South – North Access Road

Stage 2 Road Safety Audit

Kilkenny County Council

September 2024

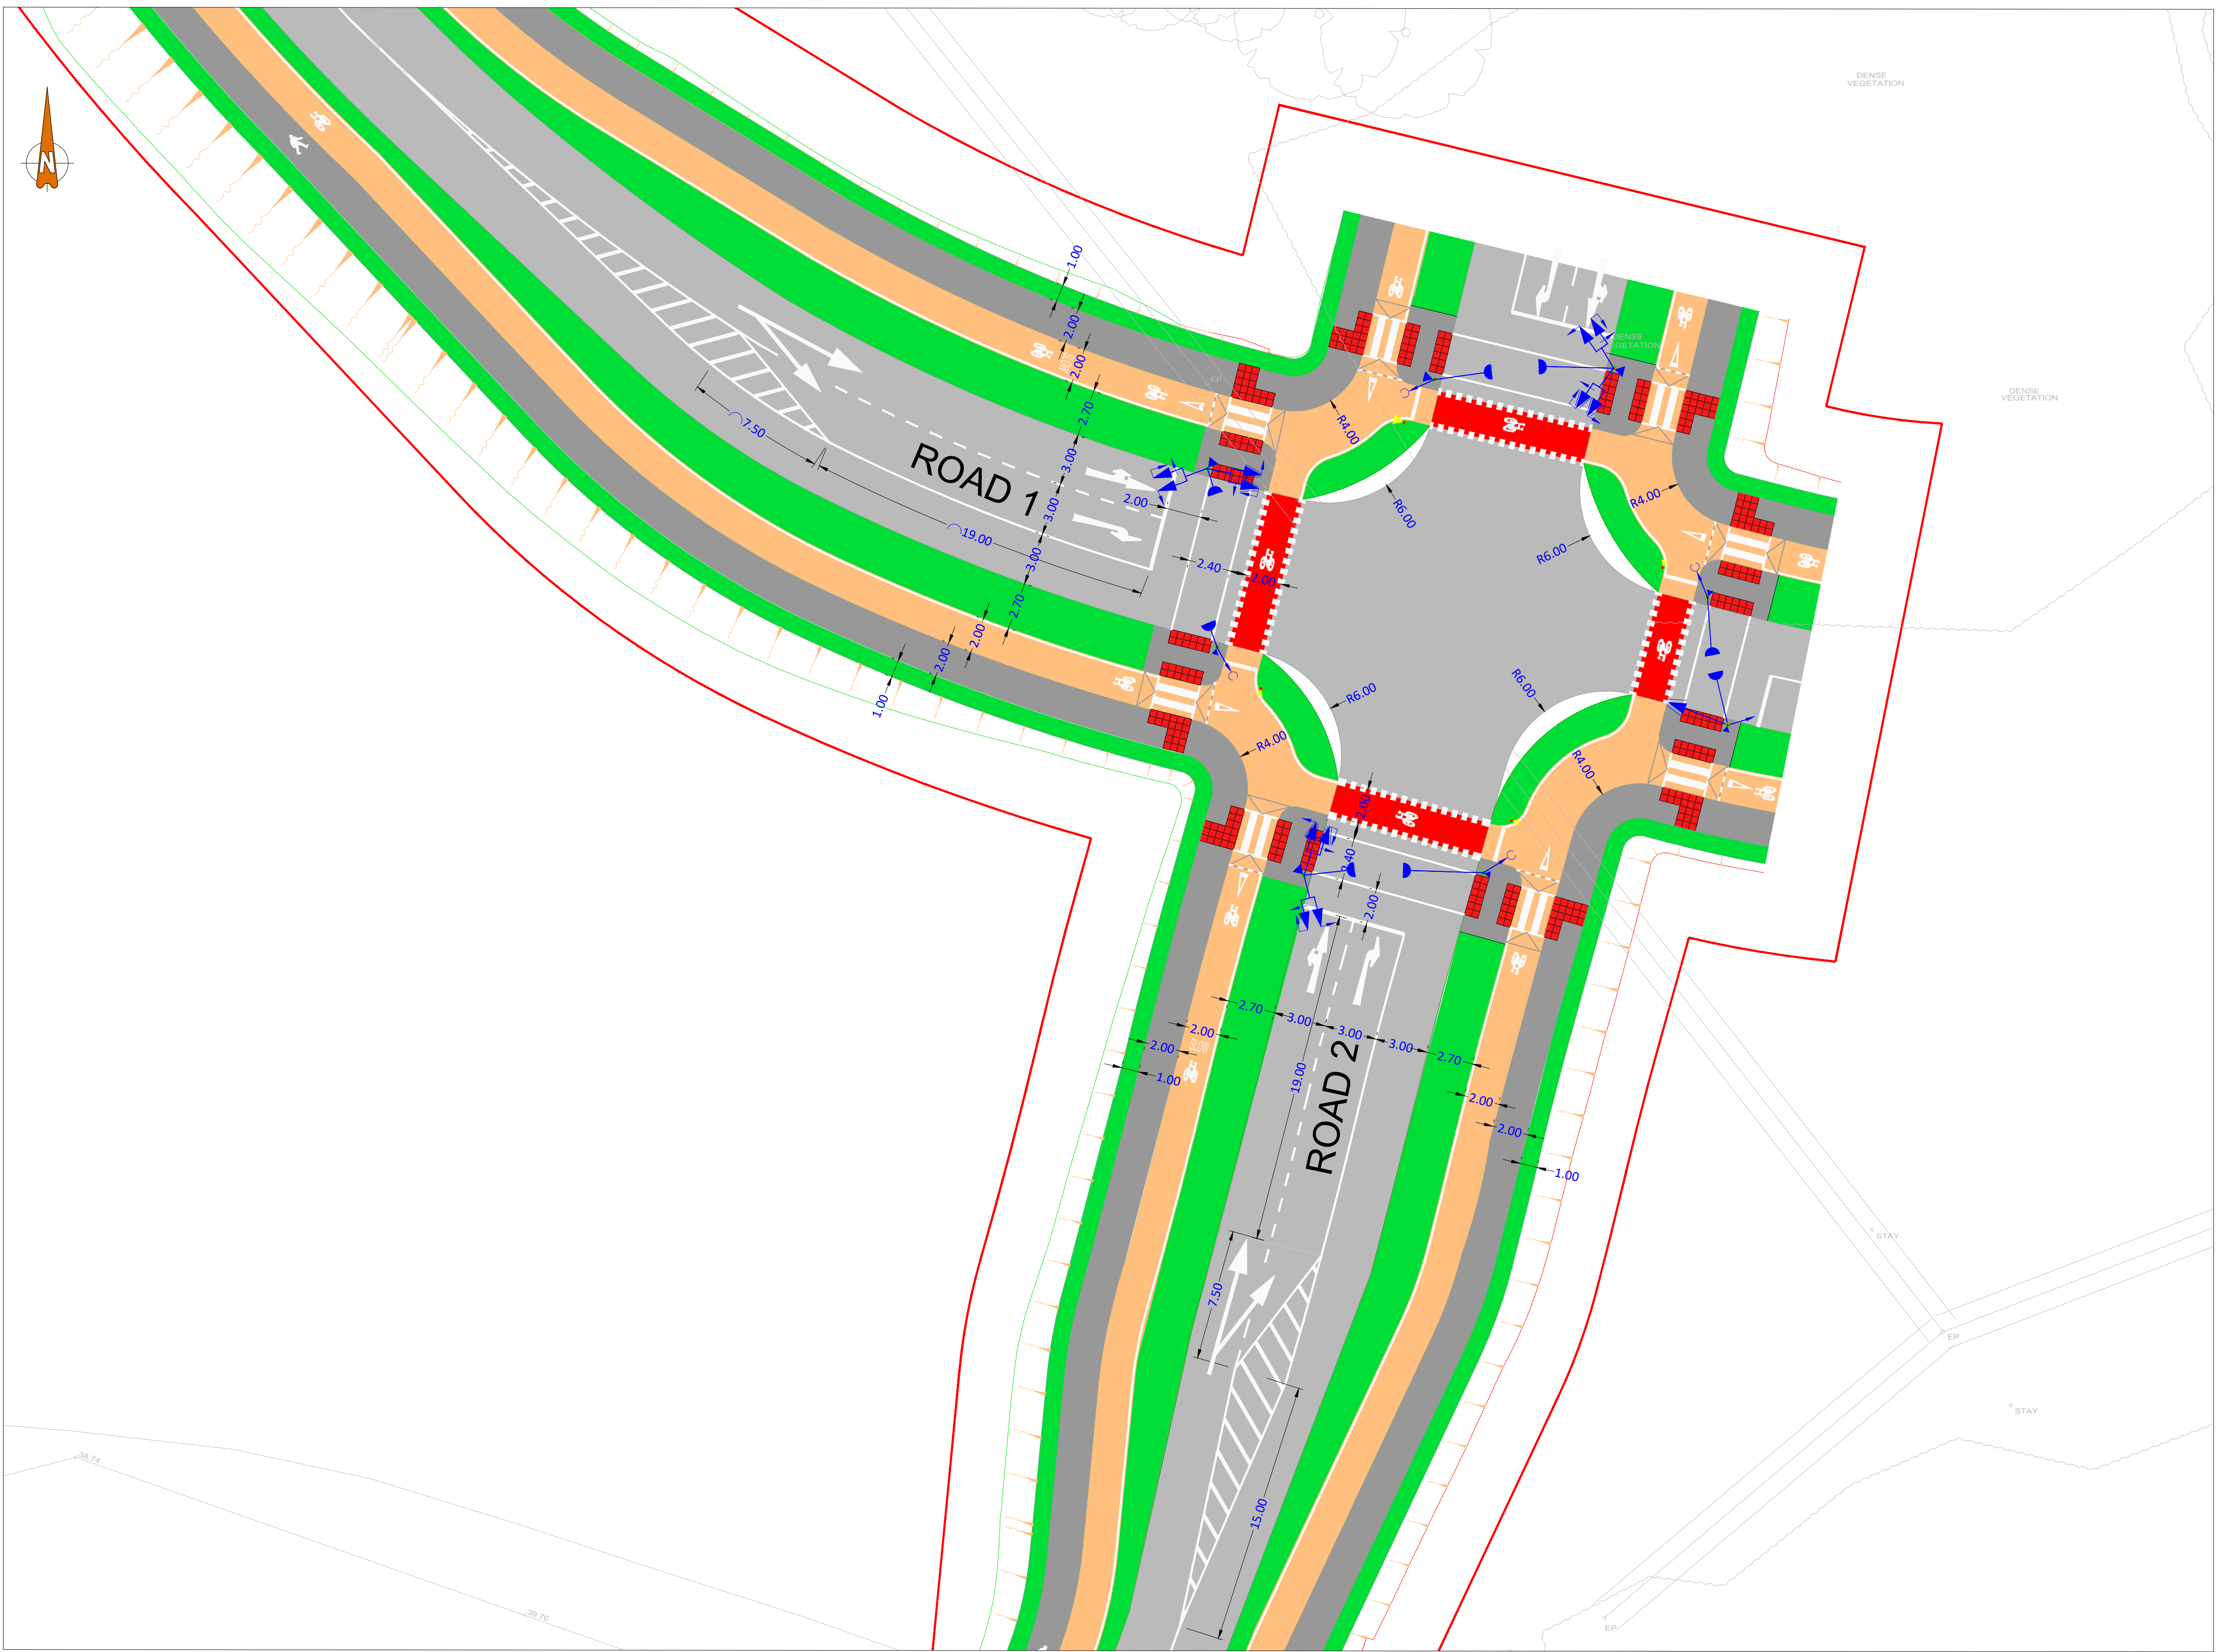
2.2 Problem: Set Back - Stop Lines & Pedestrian Crossing Lines

Location: All Signal Controlled Junctions

The unusually small set-back between the stop lines and the pedestrian crossing lines can increase the risk of conflicts between vehicles and crossing pedestrians (by way of drivers rolling past the stop line on a red light). It may also prevent the driver in the lead vehicle from having a direct line of sight to the primary traffic signal head.

The set-back between the stop lines and the pedestrian crossing lines should be increased to mitigate the risks described.

2.3 Problem: Tactile Paving May Confuse Blind / Partially Sighted

Location: Junction with The Lawn (North) & Junction with Abbeygate (South)

The tactile paving appears to be positioned to the rear of the footpaths. This may create confusion for blind or partially sighted road users, leading to poor decision making and conflicts with other road users.

The tactile paving should be re-positioned to the leading edge of the footpath, beside the interface with the adjacent traffic lane.

Problem Reference (Section 2)	Designer Response Section			Audit Team Response Section
	Problem Accepted (yes / no)	Recommended Measure Accepted (yes / no)	Alternative Measures or Comments	Alternative Measures Accepted (yes / no)
2.1	Yes	Yes		
2.2	Yes	Yes		
2.3	Yes	Yes		
2.4	Yes	Yes	Tactile on the opposite side will be provided through discussion and agreement with the relevant landowner at detailed design stage.	
2.5	Yes	Yes	Planting to be removed and appropriately reinstated in the verge at detailed design stage.

Client: KILKENNY COUNTY COUNCIL							
Project: THE SOUTH-NORTH ACCESS ROAD							
Title: ROAD MARKING AND SIGNS LAYOUT OVERALL							
Code	Originator	Zone	Level	Type	Role	Number	Status
W383	OCSC	XX	XX	DR	C	0025	S4
Date: APR'23				Scale @ A1: 1:2000		Drn by: ZS	Chkd by: PR
						Aprvd by: AH

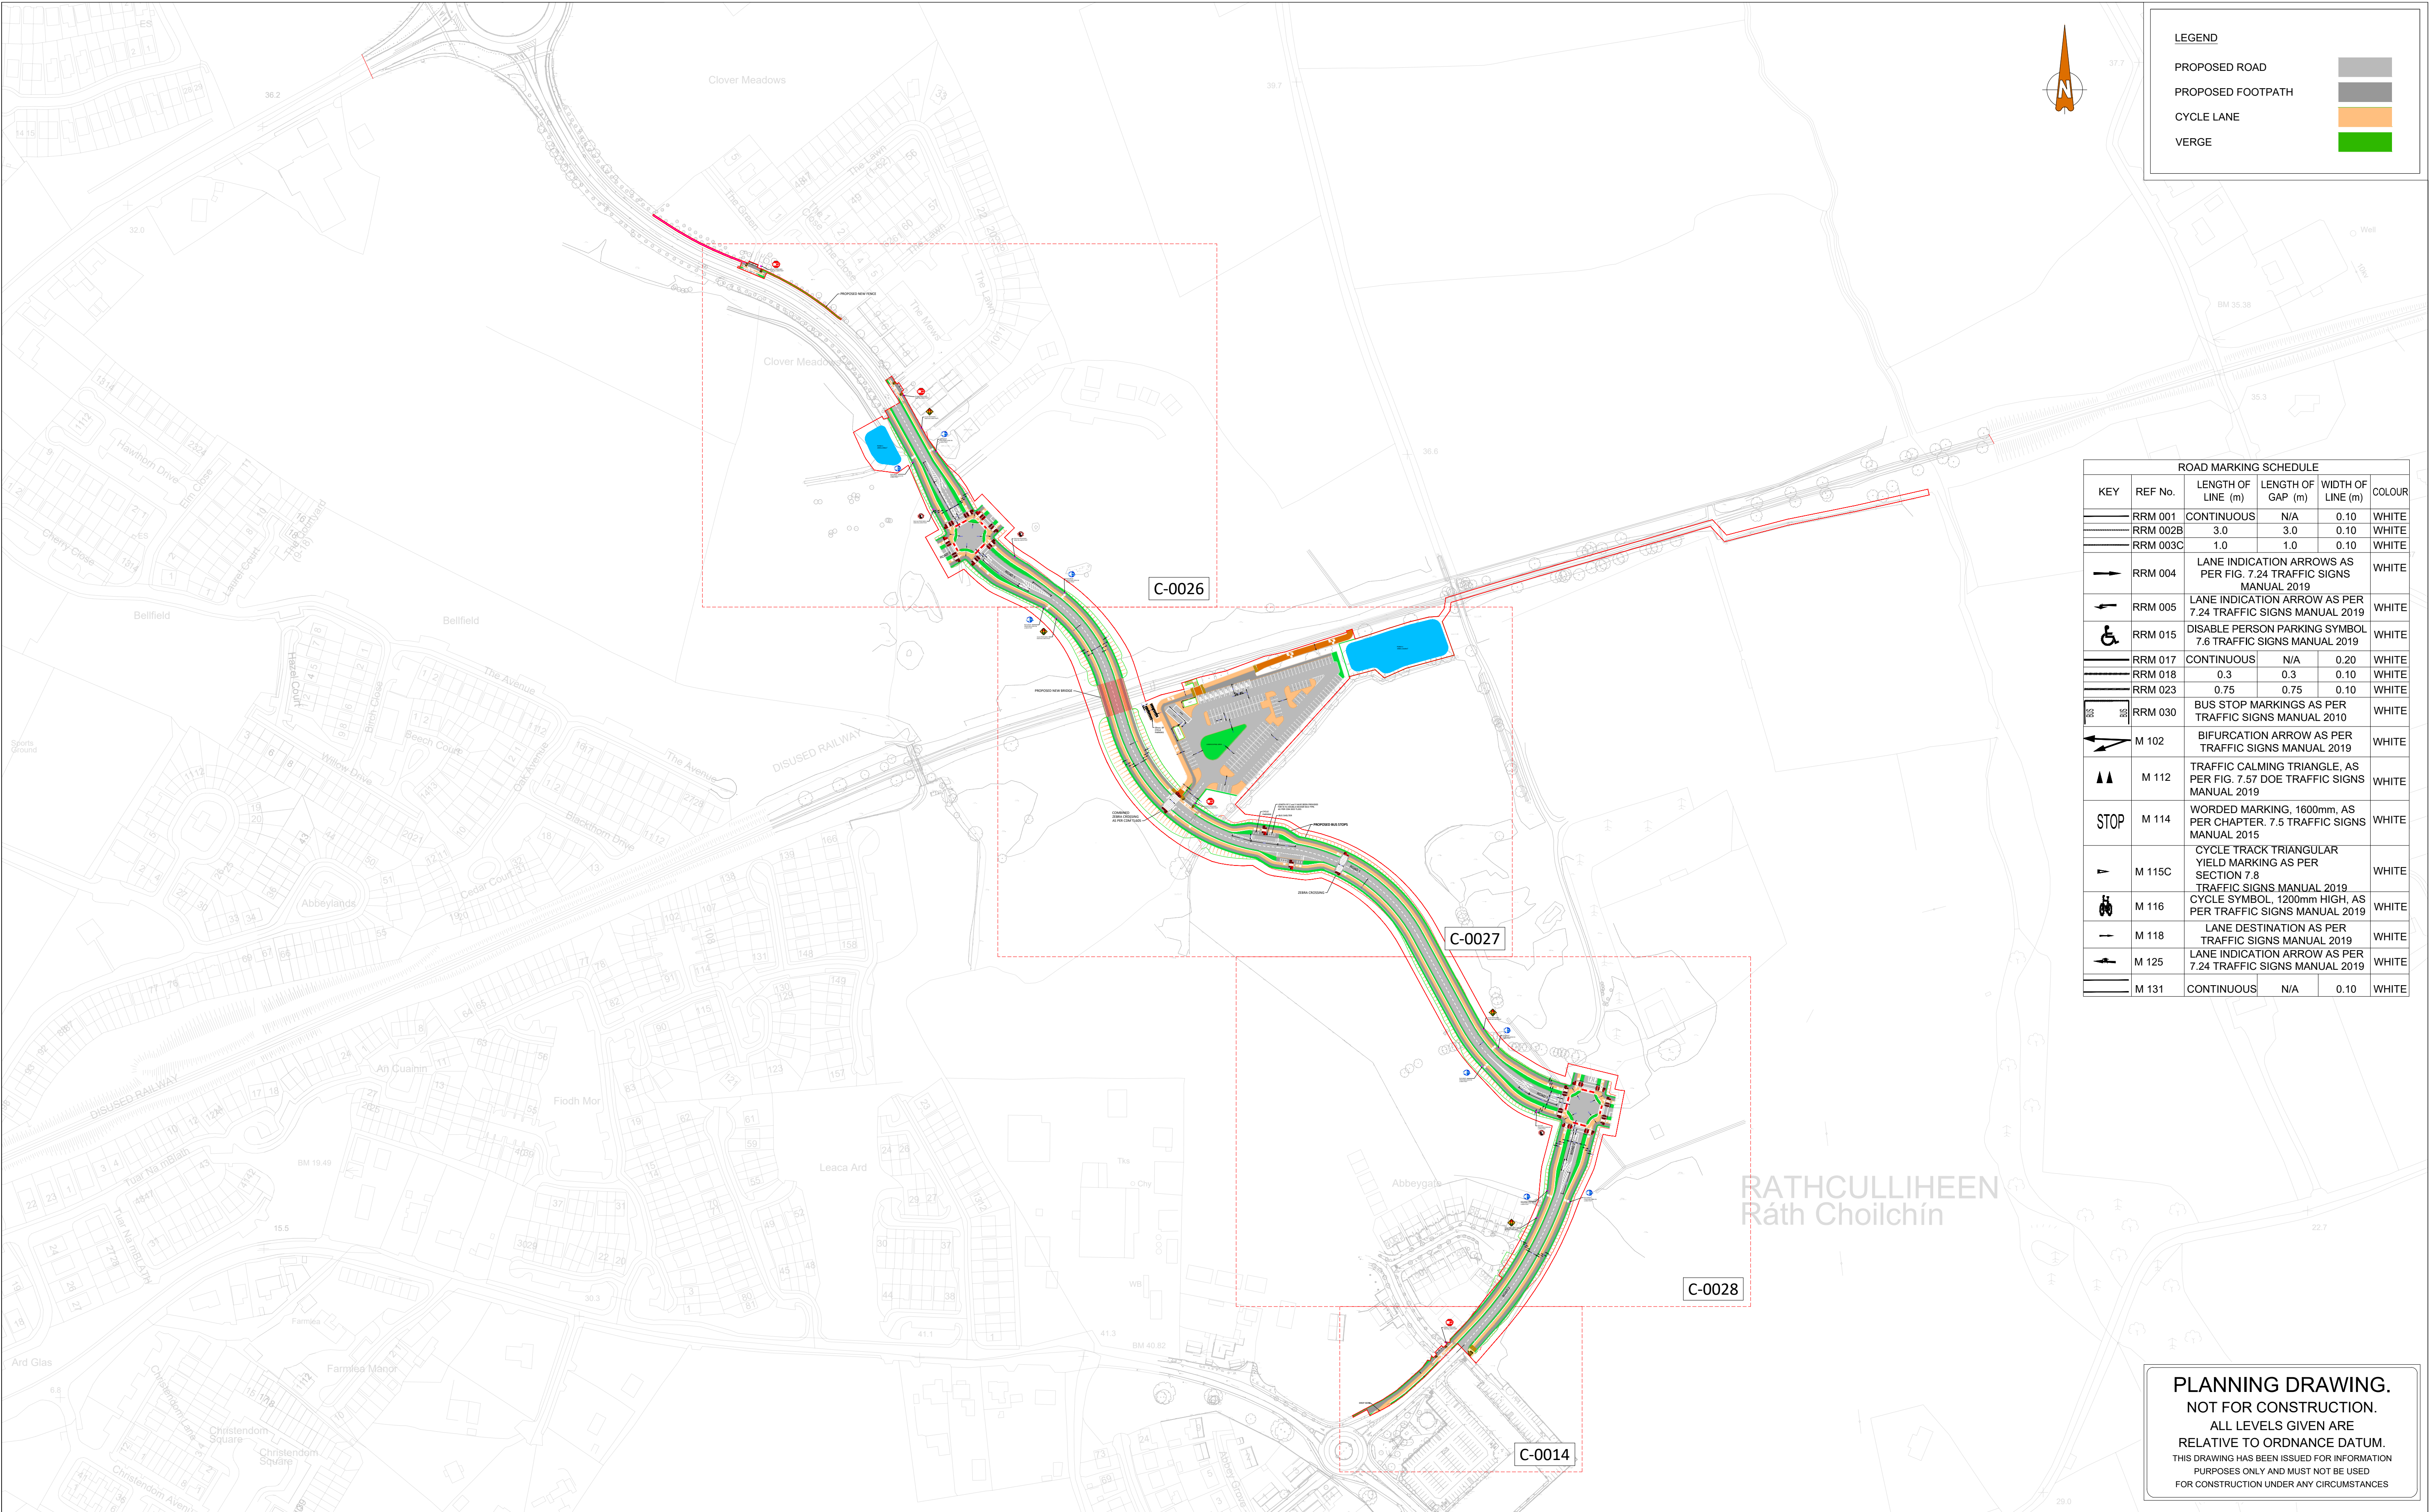
2.1 Problem: Signs / Signposts in Footpaths

Location: Various Sign Locations at Scheme Tie-Ins

Pedestrians (especially those who are blind or partially sighted) are likely to come into direct conflict with signs positioned within the footpath or at mid-footpath.

Signs should be positioned to the back of the footpath, at suitable locations where the risk of pedestrian strikes can be minimized.
